<b>Application Ref:</b>	2025/0653			 Ribble Valley Borough Council <small>www.ribblevalley.gov.uk</small>
<b>Date Inspected:</b>	27/8/25	<b>Site Notice:</b>	27/8/25	
<b>Officer:</b>	SK			
<b>DELEGATED ITEM FILE REPORT:</b>				<b>REFUSAL</b>

<b>Development Description:</b>	Variation of condition 2 (Plans) on permission 3/2023/0706 for the proposed erection of 34 Class E(g) units and one battery storage and maintenance unit with associated parking and access. Resubmission of application 3/2022/0553.
<b>Site Address/Location:</b>	Higher College Farm Lower Road Longridge PR3 2YY

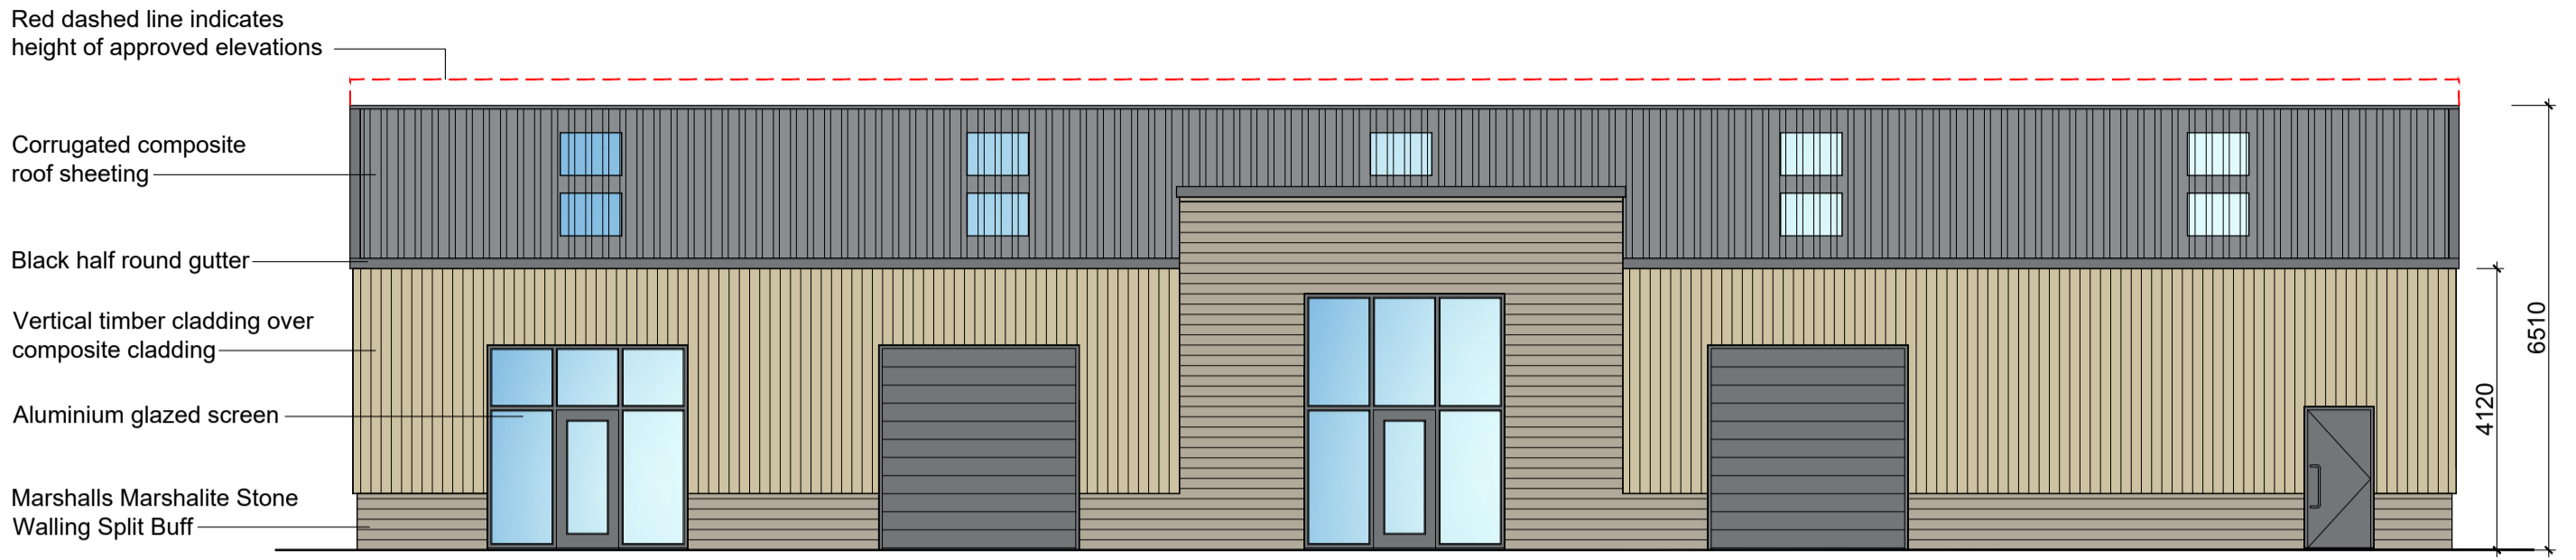
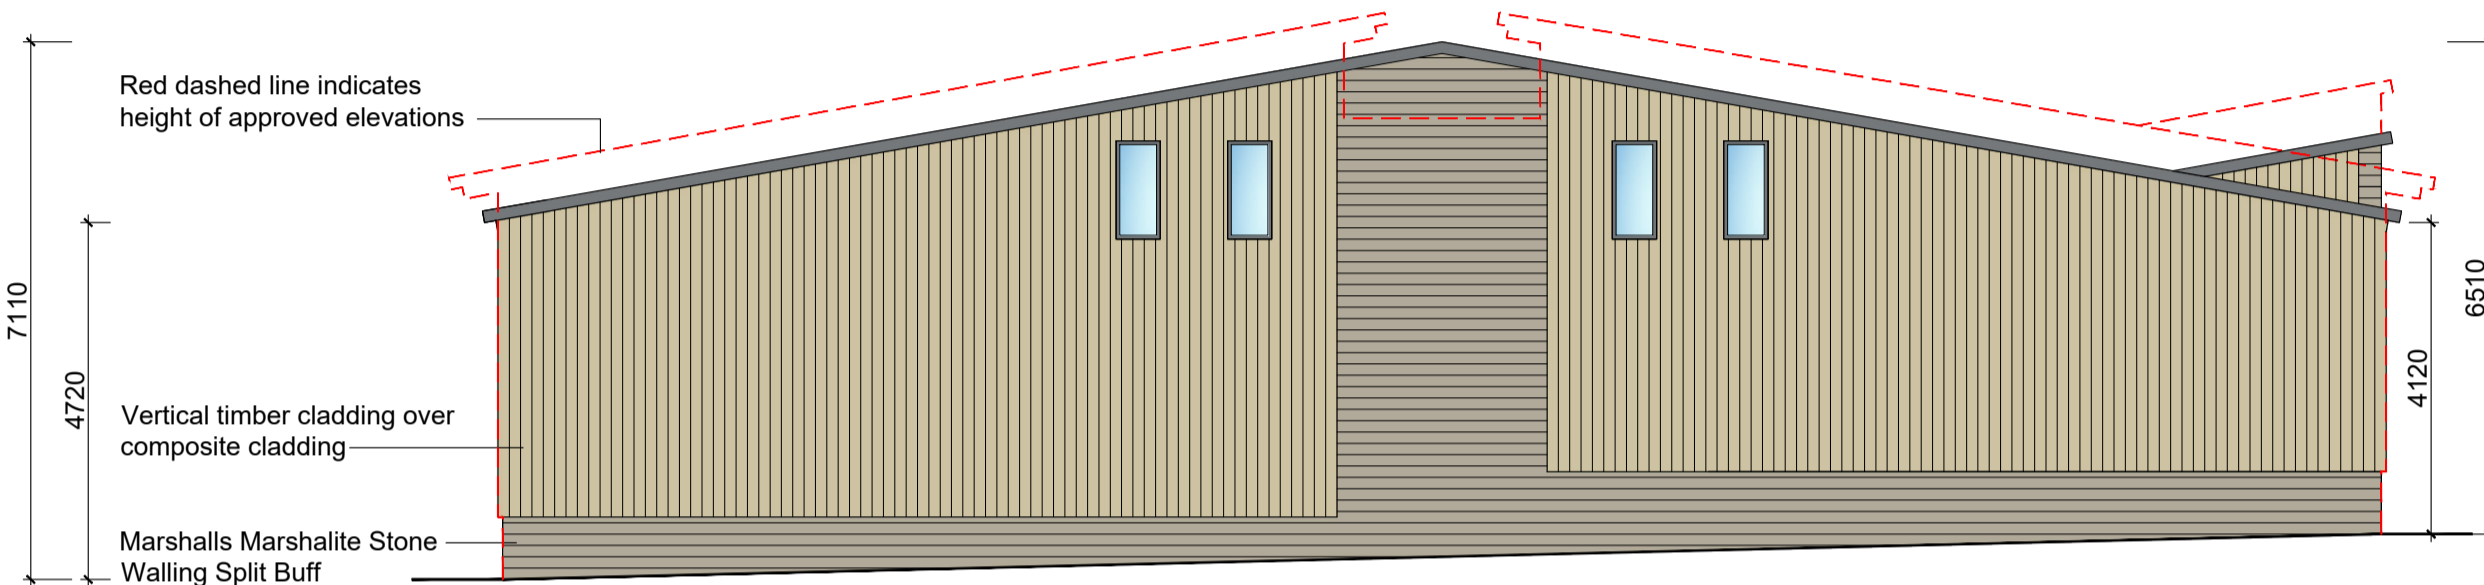
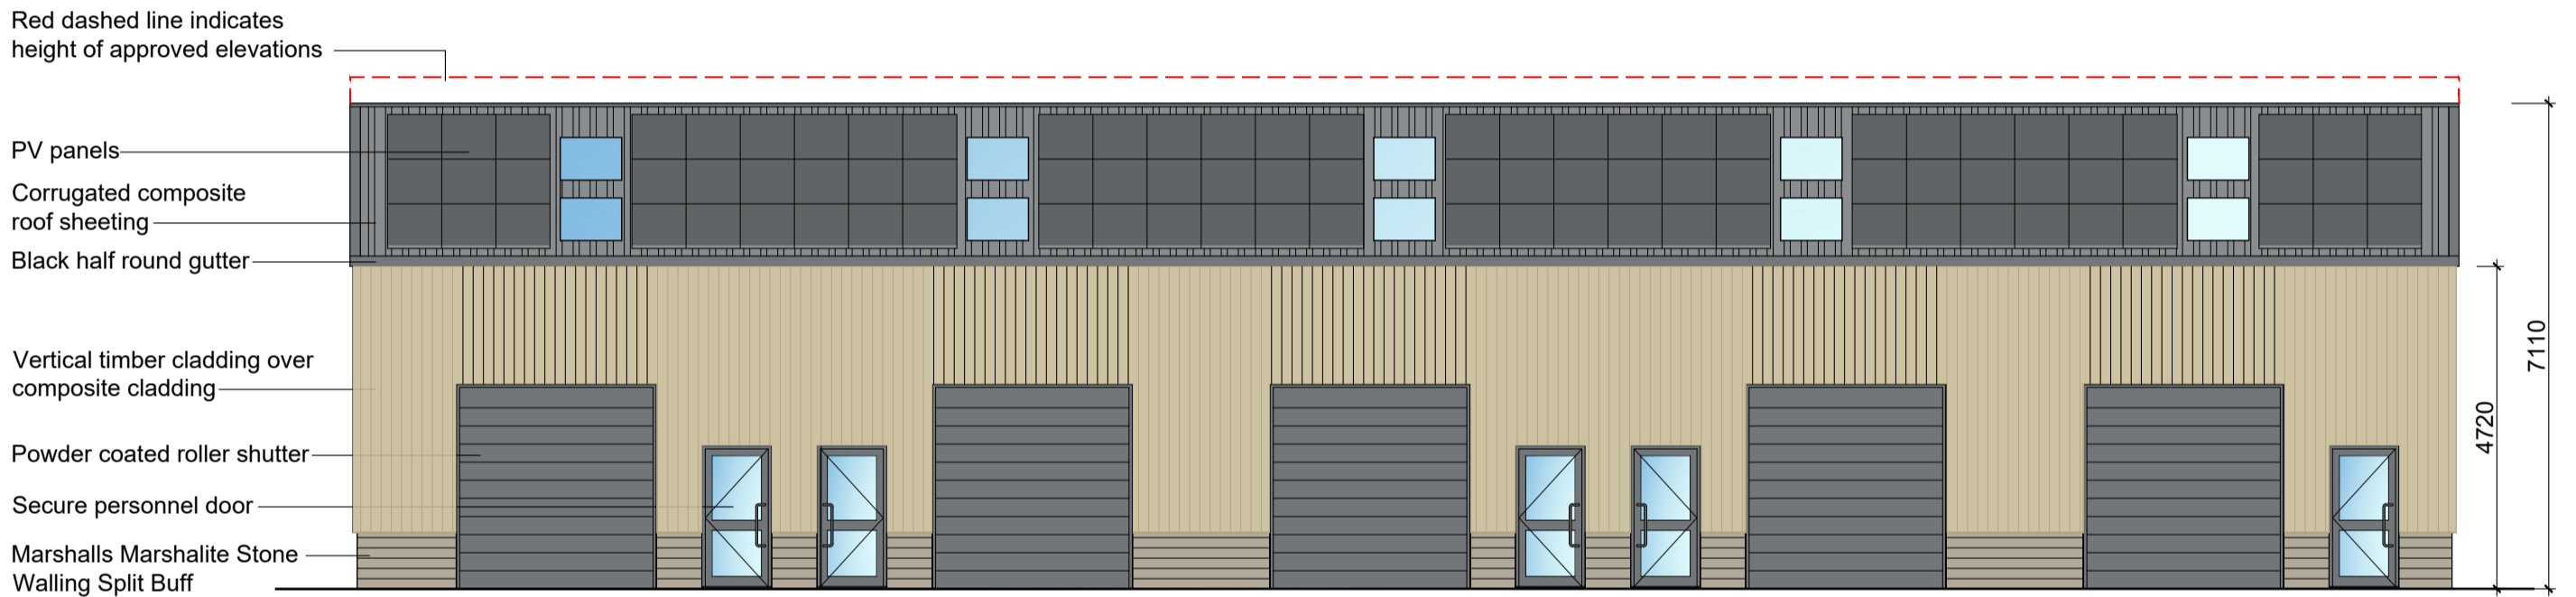
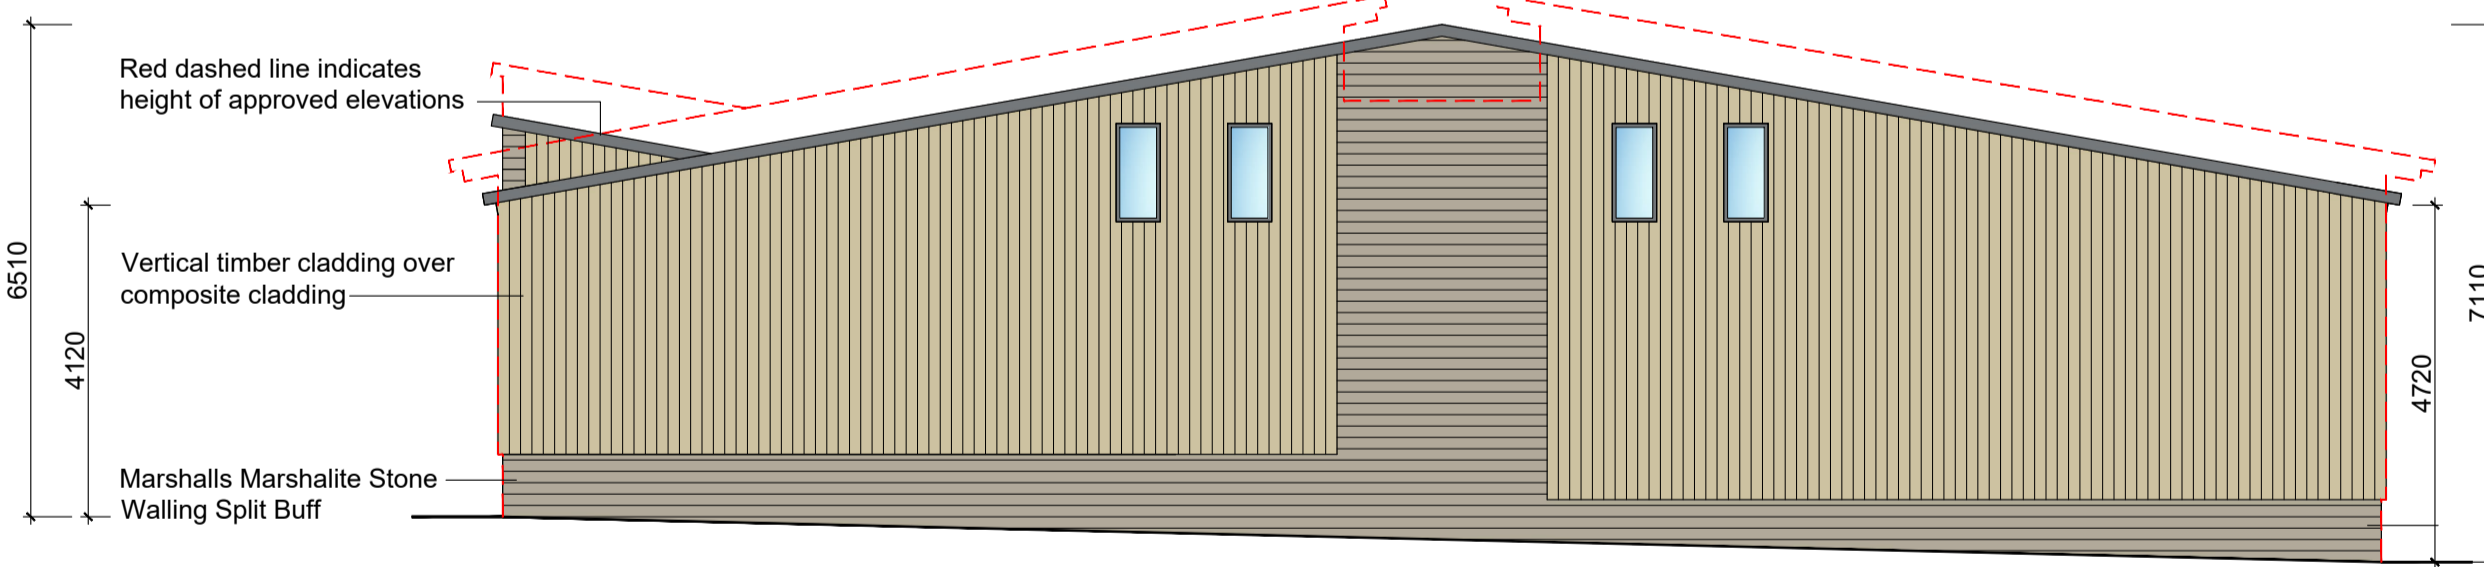
The submitted details seek to vary the originally approved roof-form of the proposed buildings with a slight reduction in height also being proposed. In this respect it is proposed that there will be an overall reduction in eaves and ridge height, the removal of the previously approved recess and associated dual mono pitched roof and a return to a dual pitch roof across each of the buildings.

The previously approved mono-pitch roof-form and central recessed elements were considered to be features that were fundamental to the proposal being supported. With the features allowing the for the overall building mass of each of the buildings to be visually broken down into smaller 'visual components' with the side elevations also possessing an element of visual depth and relief. The dual mono-pitch roof arrangement was also considered to assist in breaking down the overall visual extent of the proposed roof-form, also allowing for greater visual articulation and once again an element of relief and visual interest within the roofscape across the proposal.

In this respect the removal of these elements, whilst it is recognised there will be a slight lowering of the overall ridge and eaves height of the buildings, the overall resultant built-form and overall roofscape across the site will fail to benefit from adequate visual depth or relief, with the buildings adopting an overall stark utilitarian appearance - that would fail to respond positively to the character of visual amenities of the area, being of detriment to the character and visual amenities of the defined open countryside and the immediate area.

Taking account of the above, the proposal is considered to be in direct conflict with Policies DMG1 and DMG2 of the Ribble Valley Core Strategy insofar that approval would result in the introduction of buildings, of an overtly utilitarian appearance, that fail to benefit from adequate articulation or visual interest and fail to respond positively to the inherent character of the open countryside setting of the site, being of significant measurable detriment to the character and visual amenities of the area.
